# CITY OF ALBUQUERQUE

September 2, 2022

**Re: Phil Chacon Memorial Substation Southeast Area Command Phase I  
Request for Certificate of Occupancy  
Transportation Development Final Inspection**  
Engineer's Stamp dated 12/2/2020 (L19D043)  
Certification dated 1/9/2022

PROJECT TITLE: PHIL CHACON MEMORIAL SUBSTATION SOUTHEAST AREA COMMAND - ADDITION
DRAWING TITLE: PHASE 1 SITE GRADING PLAN

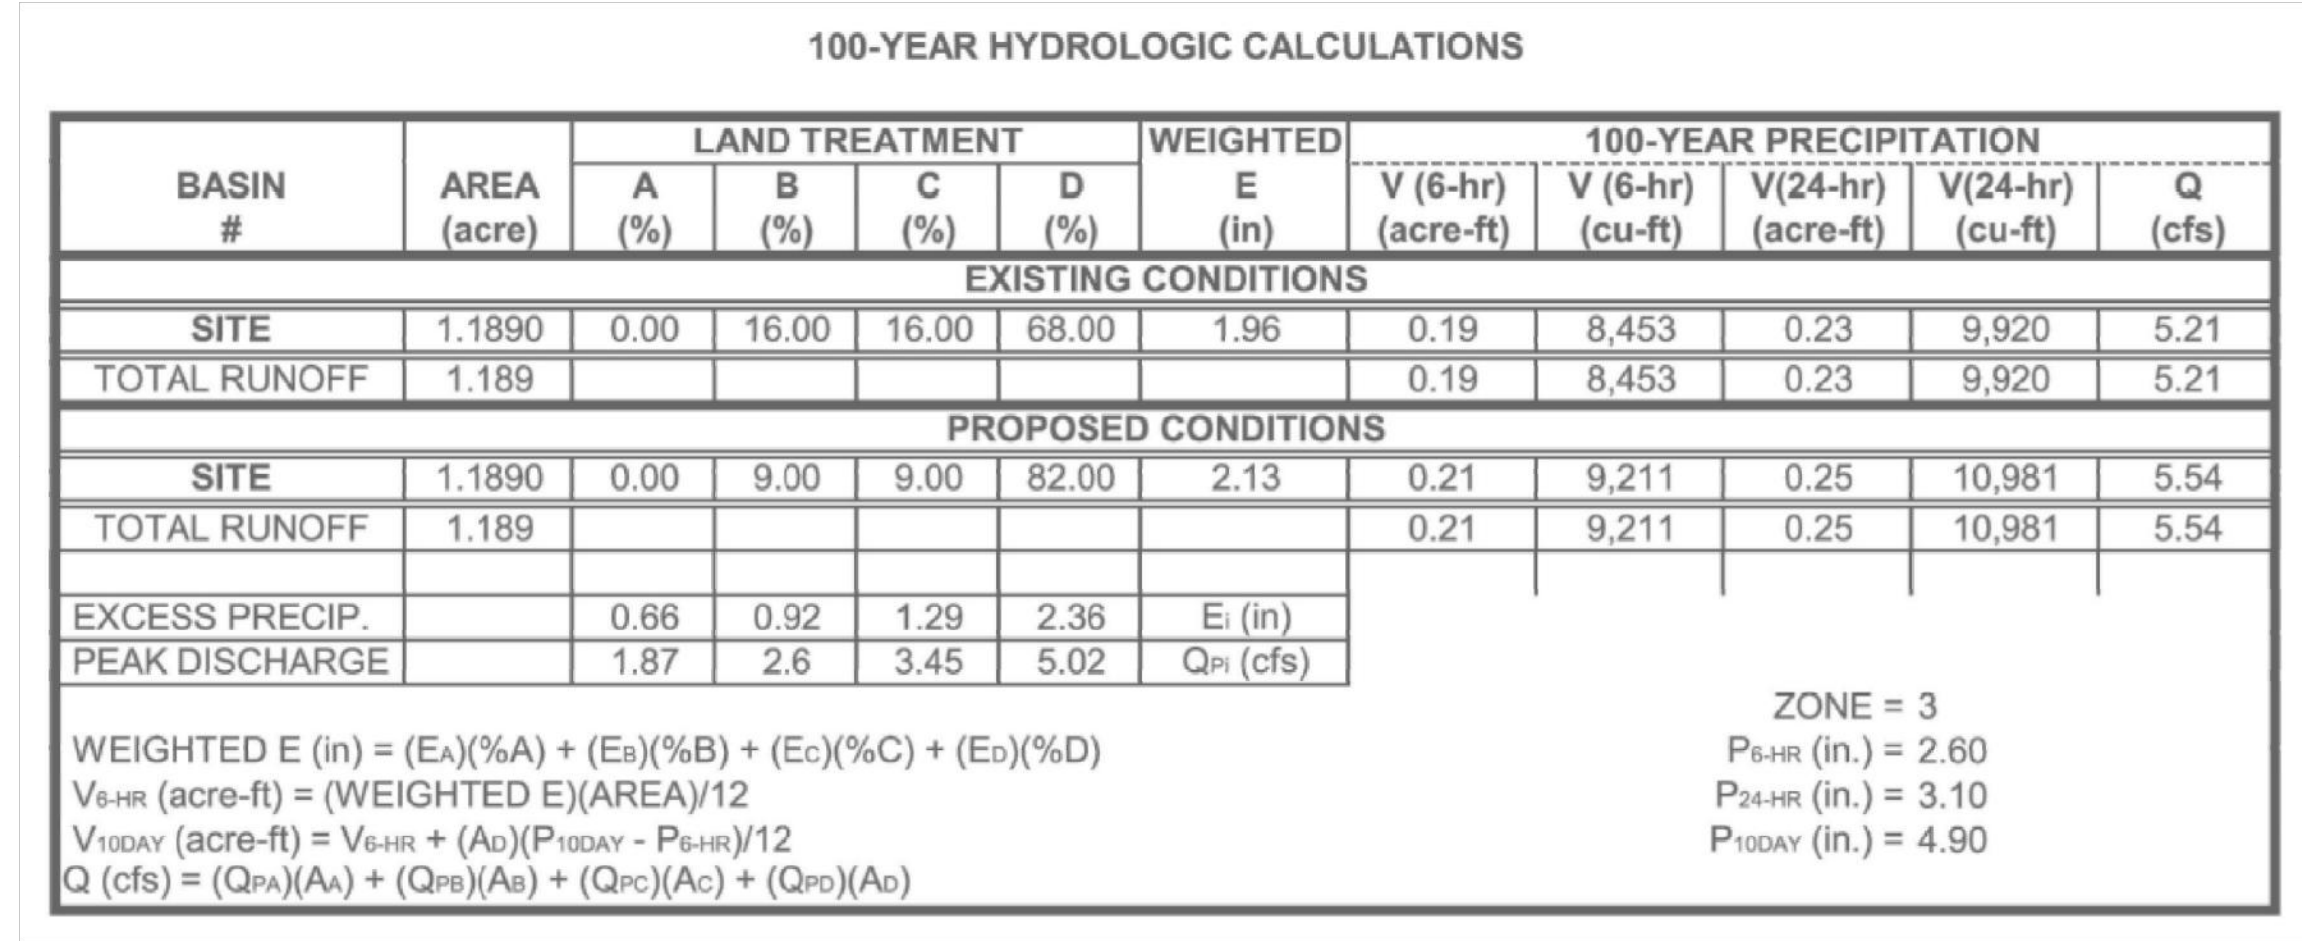
In the site visit it was noted that all parking spaces, with the exception of the spaces immediately adjacent to the south of the building, were striped at 16' long. According to the plans and City's standard designs these should have been striped at 18' long. The rest of the measurements show the site is large enough to accommodate the 18' stripes. Once this is corrected please resubmit and provide pictures to show the stripes are 18' long and we can approve the Permanent Certificate of Occupancy.
